City of Portland, Maine - Building or Use Permit Application
389 Congress Street, 04101 Tel: (207) 874-8703, Fax: (207) 874-8716

Permit No: 02-0515	Issue Date: JUN 10 2002	CBL: 339 F007001
-----------------------	----------------------------	---------------------

Memo

To: Dwight Brackett
From: Mike Nugent
Date: 06/18/2002
Re: 11 Haskell St. (339 F007)

Drawing Name:
LOT 1 SITE LAYOUT & UTILITY PLAN

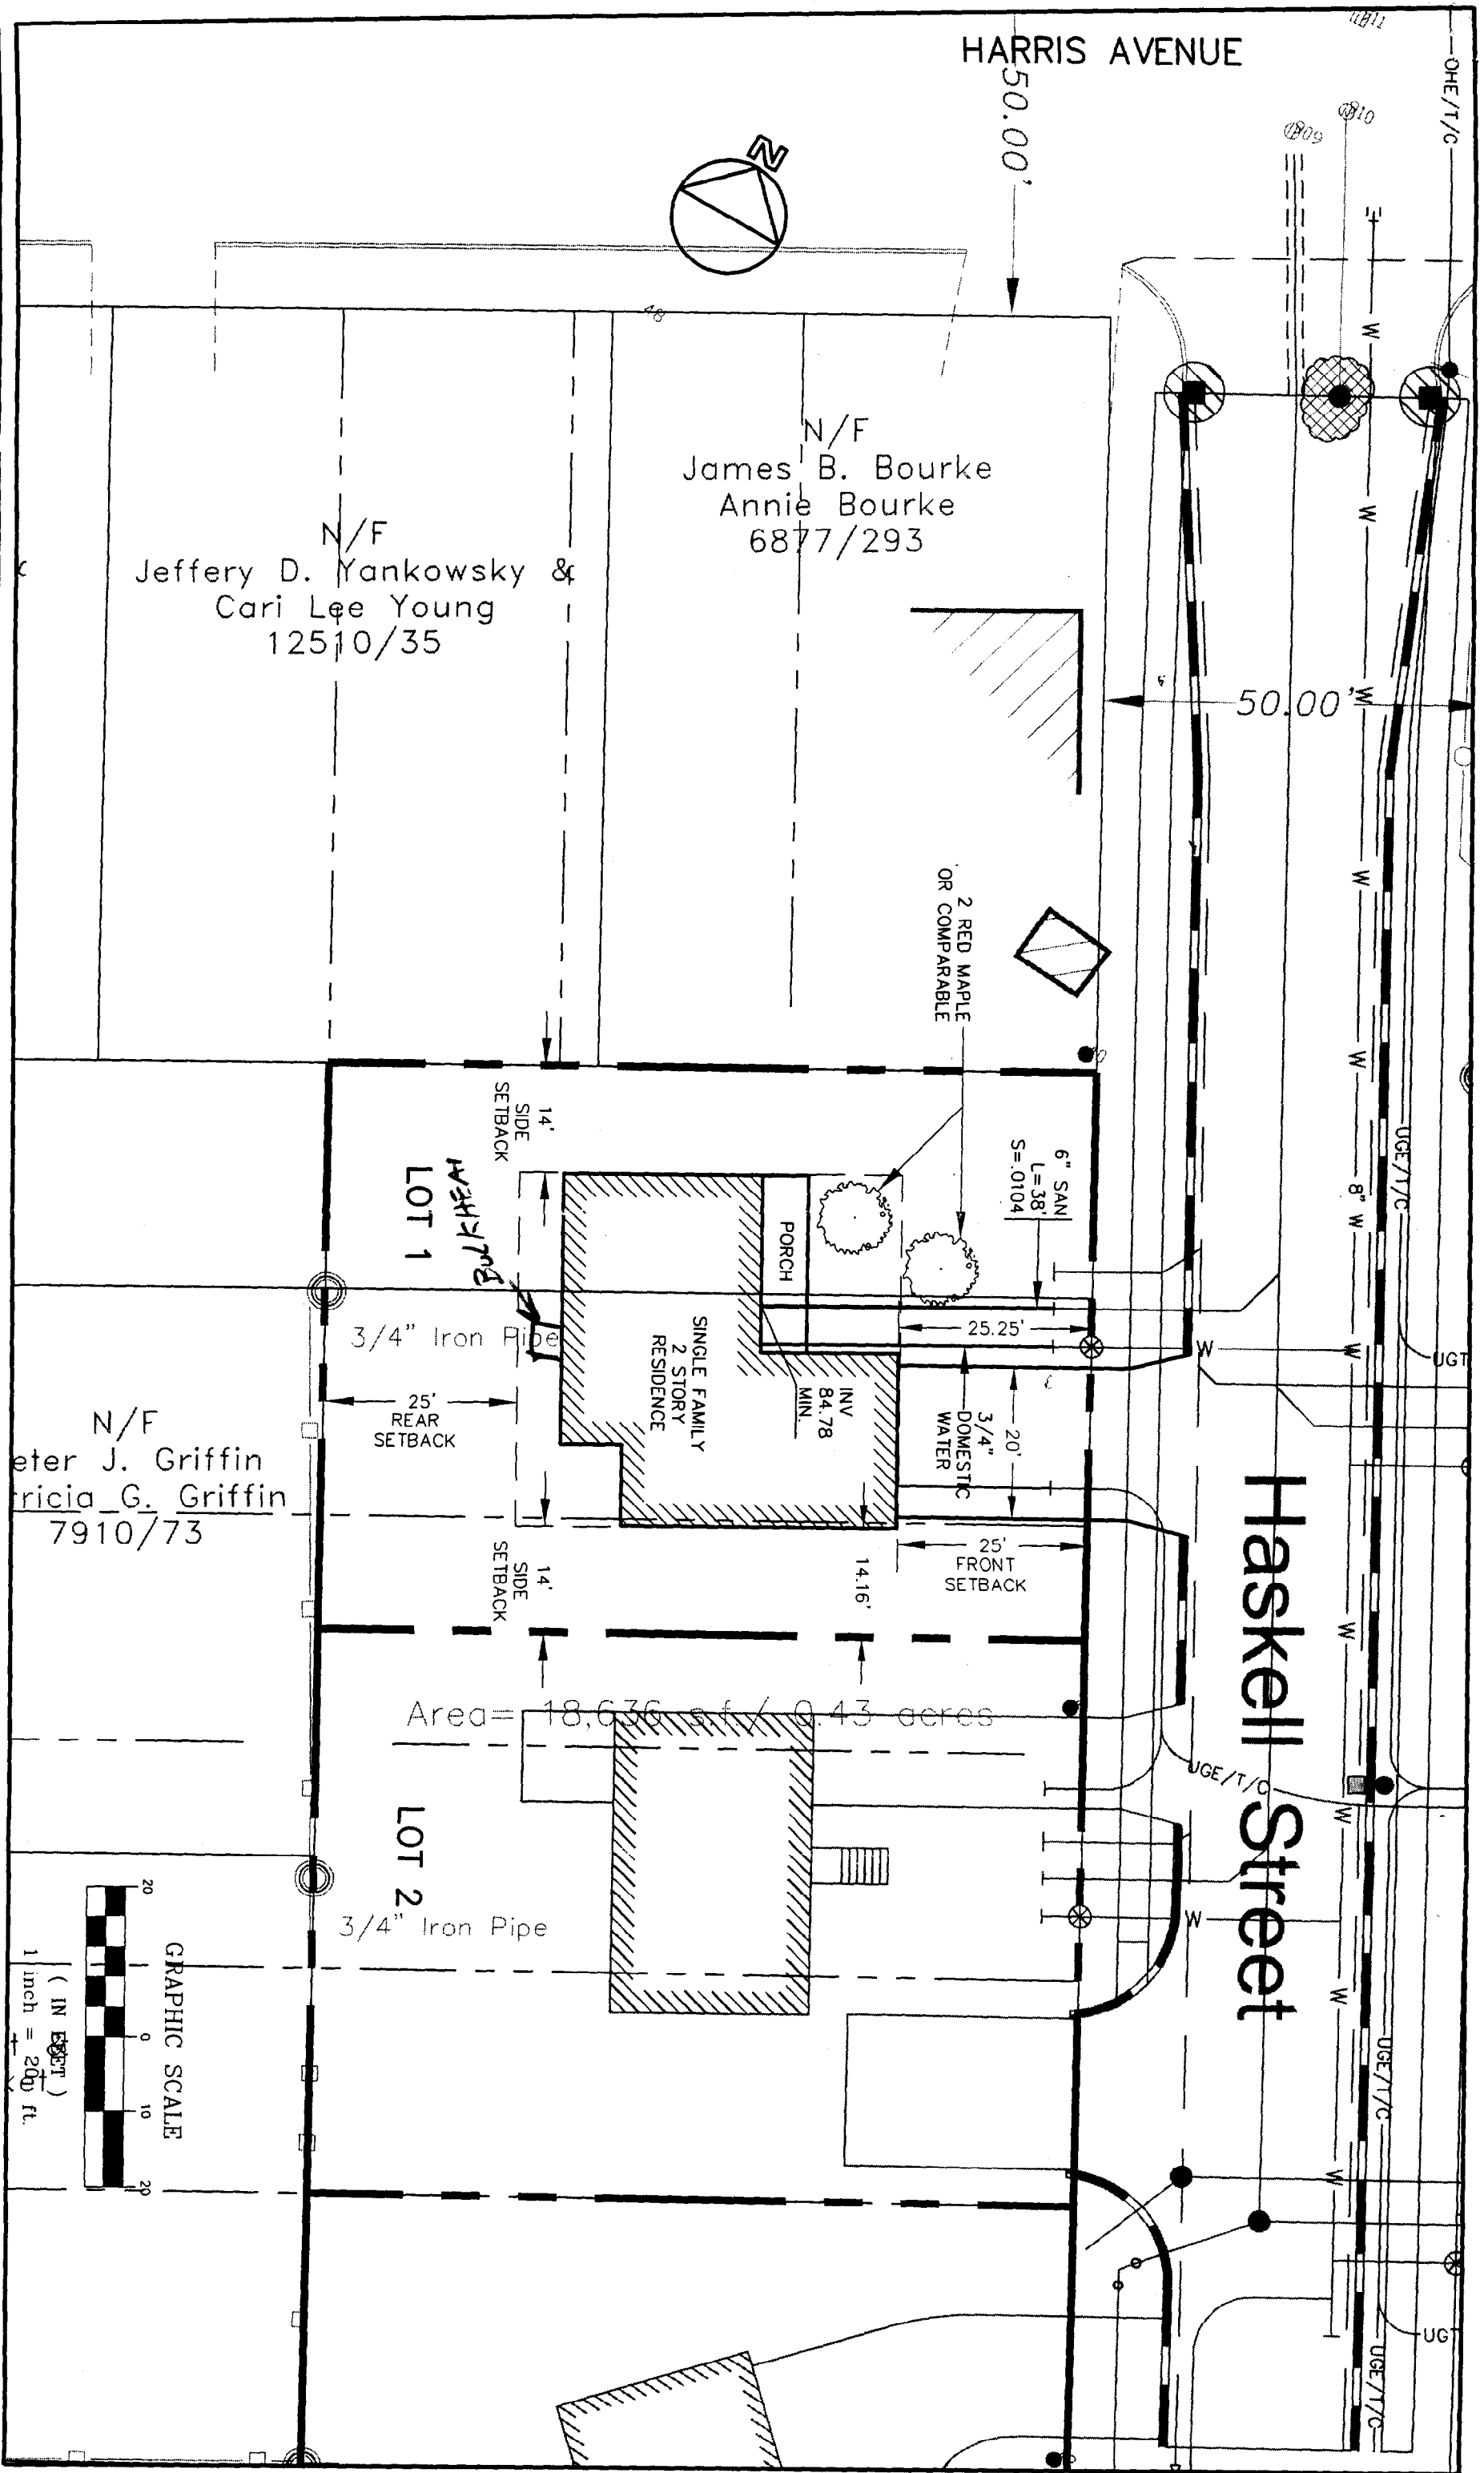
NO DECKS are shown on your plans and NO DECKS are being approved. Separate permits are required for ANY future decks. PLEASE NOTE that the rear setback is very close to the rear of the house and that the maximum lot coverage of 25% is presently shown near the coverage capacity allowed.

All setbacks are very close to meeting the minimum requirements. You will be required to verify the setbacks by a surveyor when required by the Code Enforcement Officer.

SECTION THRU HOUSE
 SCALE: 1/4" = 1'-0"

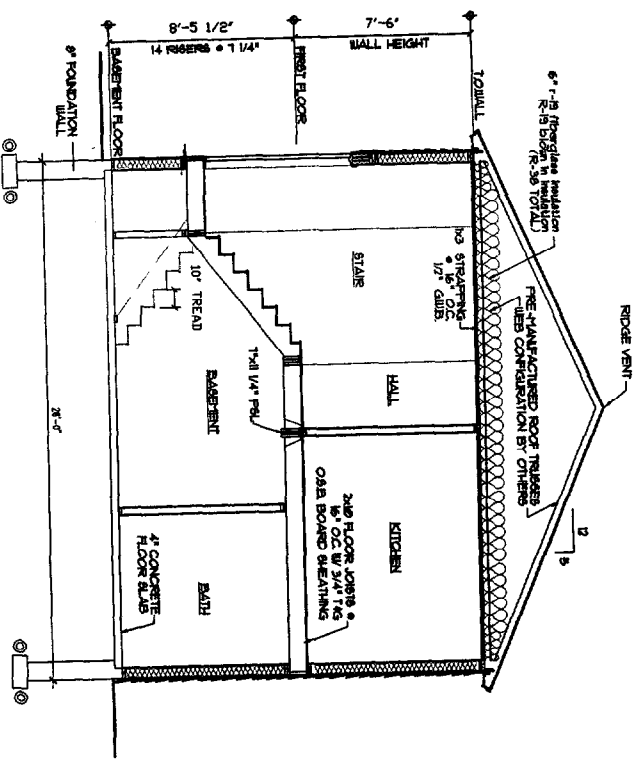
- 1) Height of Guards and baluster spacing for the farmer's porch rails, roof rafter size, spacing and fastener detail. ✓
- 2) Rear Steps are not on the site plan and are not approved. Marge Schmuckal and Jay Reynolds must approve this. Consequently the rear door cannot be approved without code compliant protection. ✓
- 3) The 8' spacing of the lally columns is excessive w/ 3 - 2" x 12" girder. ✓
- 4) The spacing of the farmer's porch carrier is excessive. ✓
- 5) Beam Info not clear ✓
- 6) Header detail for the 5' and 6' openings in the first floor floor plan, bearing wall ✓
- 7) Are the 3046 Windows egress approved ✓
- 8) Attic access ? ✓
- 9) Garage fire rating , walls and ceiling? Detail and what kind of door? ✓ *45 min*
- 10) Open or closed interior stairways? Handrail/guard rail details ✓
